352 Danko Road
Cle Elum, WA 98922
25 September 2008

Subject: Comment on the Airport Heights Rezone (RZ-08-00009) and Preliminary Plat (LP-08-00026)

# Airport Heights Planned Unit Development Concept Map ~ 34.29 acres

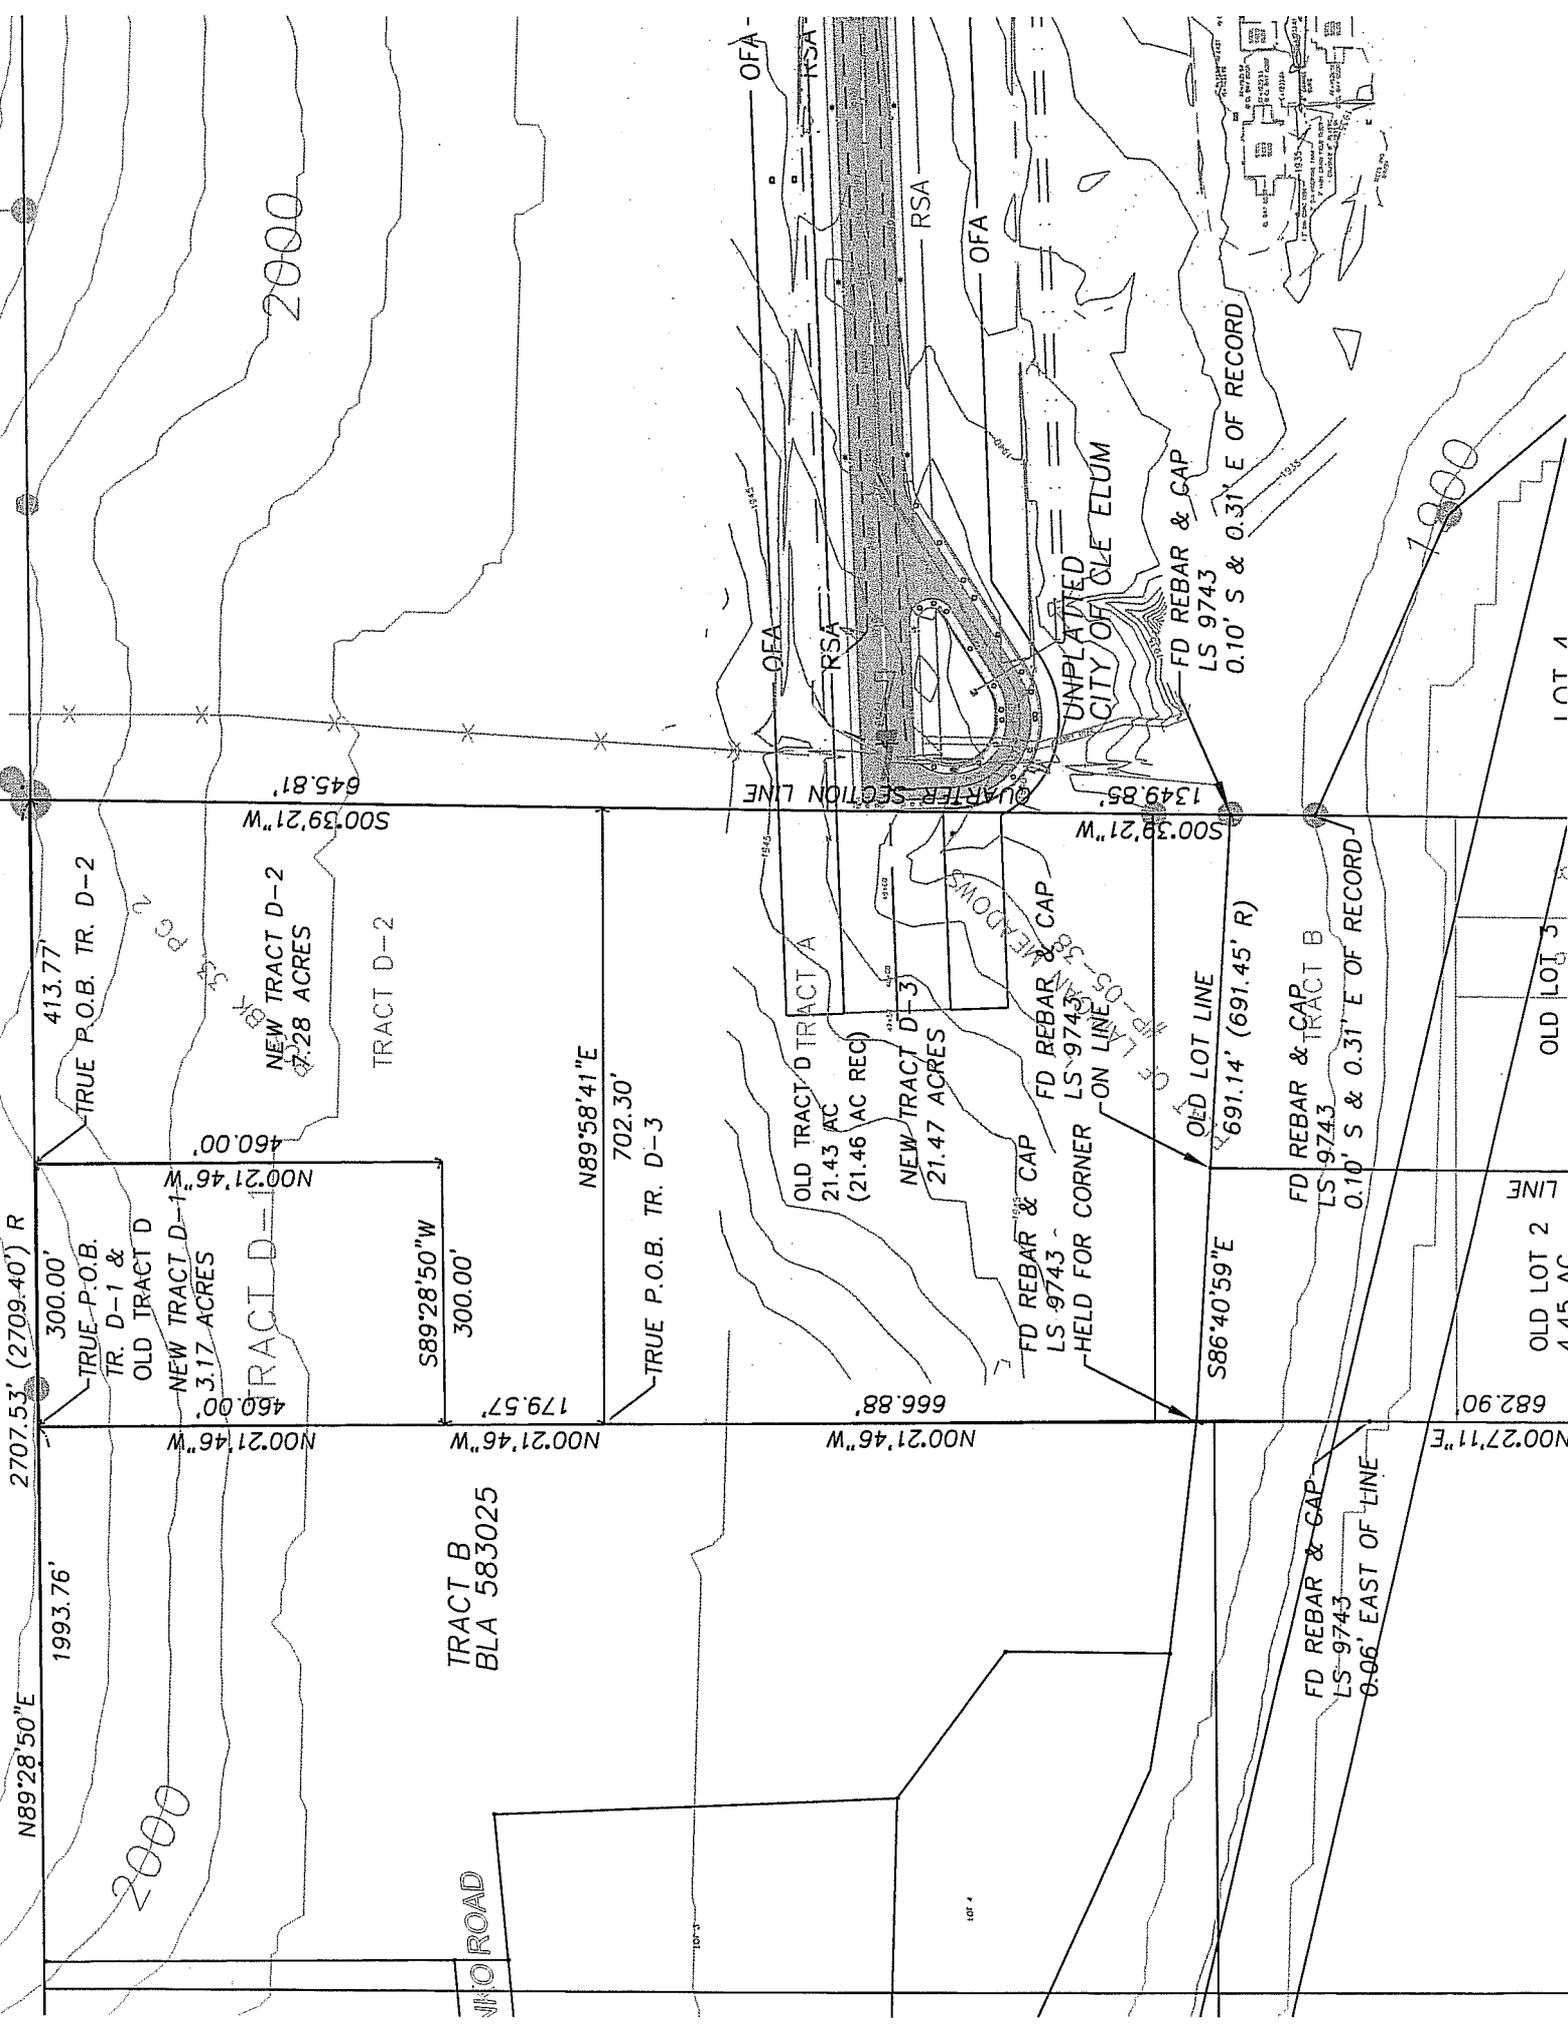
We own the property at 352 Danko Road, which is located at the end of the existing Danko Road with a driveway that exits from the existing cul de sac. The north property line adjoins the proposed extension of Danko Road. This property is at the lowest elevation of the existing and proposed extension of Danko Road.

Poor drainage design of the existing Danko Road allows all the runoff from Danko Road to collect in the cul de sac and flow down the 352 Danko Road driveway. Though it was exacerbated by snowplowing (large piles directed the run-off), the result was unacceptable. See Attachment 2 with photos of runoff flooding from last winter. *We request that improved drainage and adequate snow storage for the existing road and extension be required of the developer to prevent flooding the residence at 352 Danko Road.*

The existing cul de sac of Danko Road encroaches on the 352 Danko Road property. *We request that the developer be required to remove all road base materials from the property except the existing driveway and move the rocks currently delineating the edge of the cul de sac to the property line. We request that the driveway be brought to the new grade of Danko Road using*

We are concerned about environmental damage done to our property by the developer as they extend Danko Road along our north border. Our property extends past the 'gully', over which the developer will normally place 'fill' (along my fence line). We do not approve of 'fill' on our property, or burying our fence line. *We ask that the road design and construction be done to prevent any 'cut or fill' on our property.* The developer recently put in a PUD below the proposed area, and excavated the 150' bench leaving bare earth and weeds. This is unacceptable and we request that any 'cut and fill' bare earth be appropriately designed for erosion control, weed control, and properly seeded. The Kittitas County Weed Board should hold the developer accountable (as they do ourselves as a landowner) for appropriate weed control.

We are concerned about wildfire safety egress. The proposed PUD extends Danko Road as a 'dead-end cul-de-sac'. But us upwind neighbors (to the west) need downwind egress (to the east) in case of wildfire. We recommend an emergency access through the airport to Airport Road. We actually had a KC Sheriff Deputy come to the door on his trail bike and warn us that we should prepare to evacuate our house because of a wildfire to the west. This was a real event and it raised awareness of the need for safe exit during a wildfire situation. We request the county stipulate that Danko Road be designed to allow public emergency egress to the east. This would be advantageous for the Lannigan Springs and Sapphire Skies developments to the north also.
